Consultation Response from: KC Environmental Health (Pollution & Noise Control)		
2025/90448 - Batley Bulldogs RLFC, 7 Heritage Road, Batley, WF17 7NZ		
Conversion of derelict bowling green to 2 padel courts and associated works		
Responding Date: 12 June 2025	Responding Officer: Mohammed Nasim	Responding Ref: WK202517216
<u>Comments</u> <u>Noise</u> The applicant has submitted an undated Noise Impact Assessment authored by MZA Acoustics Ref 1701943 ~ Padel Courts Batley/Noise Impact Assessment. The report assesses the potential for noise impact from the outdoor padel courts on the nearest noise-sensitive receptors (NSRs) as shown in figure 2. An environmental noise survey was undertaken over a period of 5 days between 1600hrs on Wednesday the 12th and 1430hrs on Monday the 17th of March 2025 from a single monitoring position as shown in figure 3 and a summary of the findings is shown in table 4. Para 4.6 describes the noise climate and observations made on the activities in the area during the monitoring period. There is no previous guidance or assessment methodology in the UK specifically relating to noise from the proposed uses at the site and reference is made to the Sport Engl

Figure 5- Luminaire layout

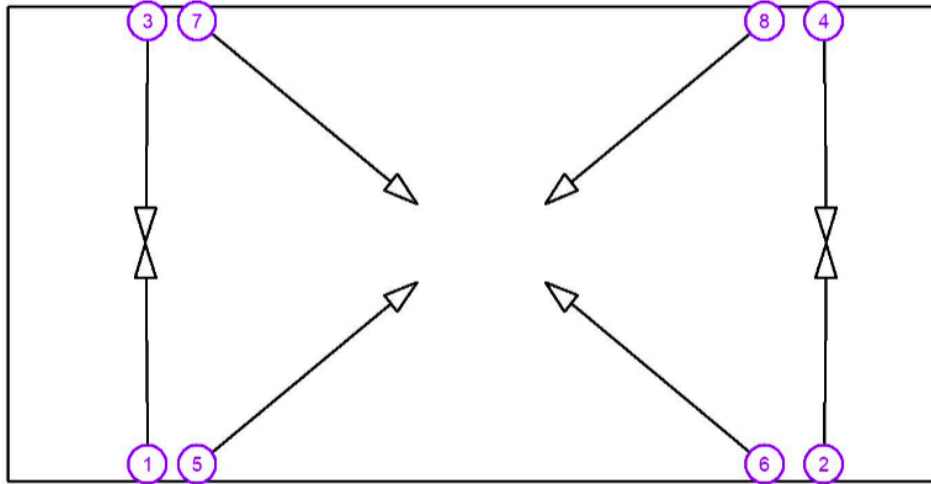
Based upon the type and specification of lighting as shown in section 4 which is as per Lawn Tennis Association (LTA) requirements, along with its proposed location as shown in figure 5, the report determines the light levels are within the limits prescribed by the guidance for minimising obtrusive light as shown in table 6.

The findings of the report are accepted and a condition is recommended to secure this scheme in the interests of protecting amenity.

No external artificial lighting shall be used unless the lighting has been installed in accordance with the details provided in the Lighting Impact Assessment authored by DfL dated April 2025. The installed external artificial lighting shall be operated thereafter in accordance with the approved scheme.
